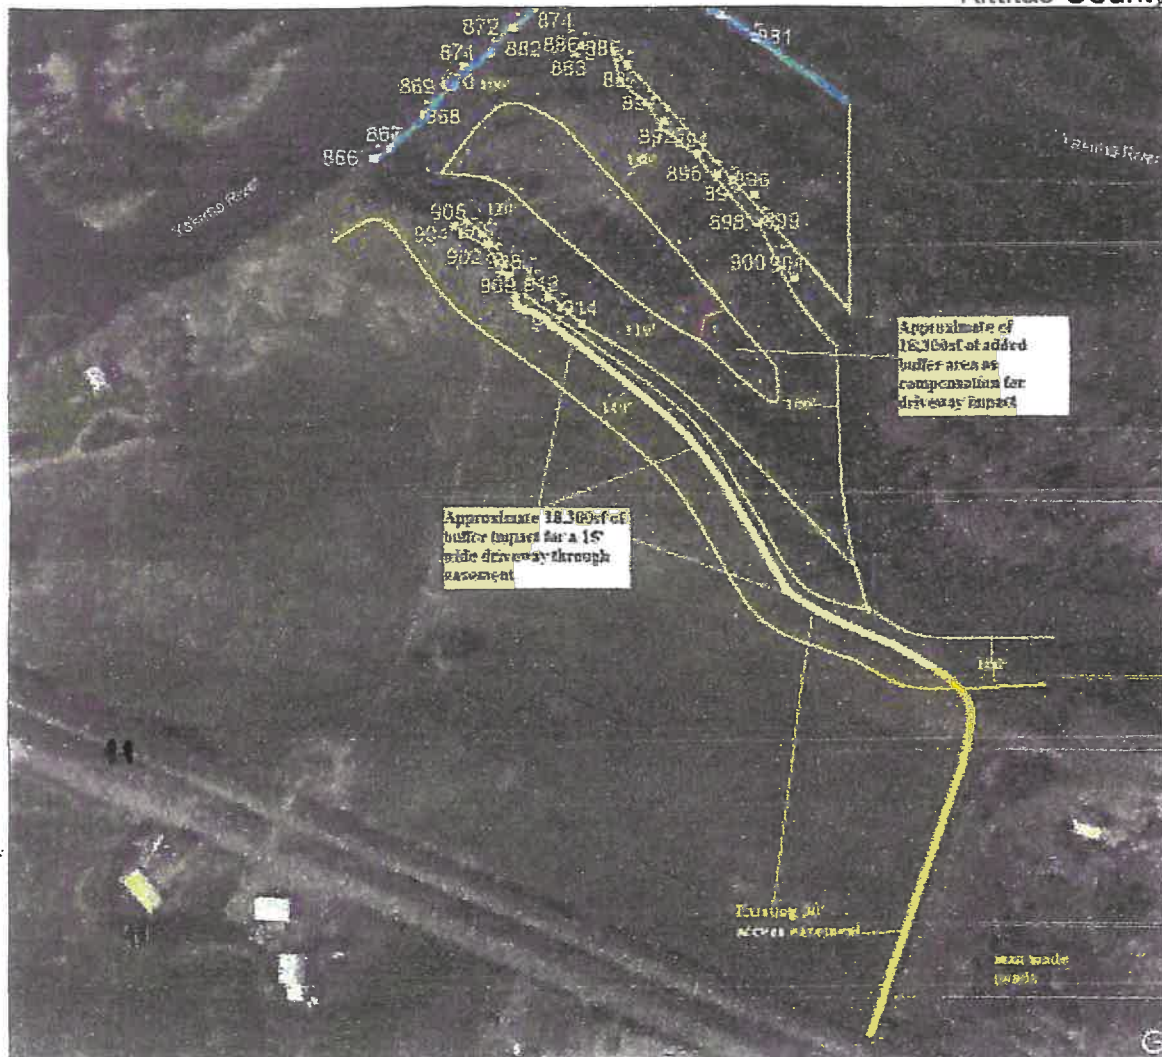
**The application should provide a site plan that shows these alternatives as part of a complete application.**

The property was sold as pasture only – open space land. The only plausible alternative, for an easement to access Parcel No. 516534, is along the edge of Montgomery's pasture.
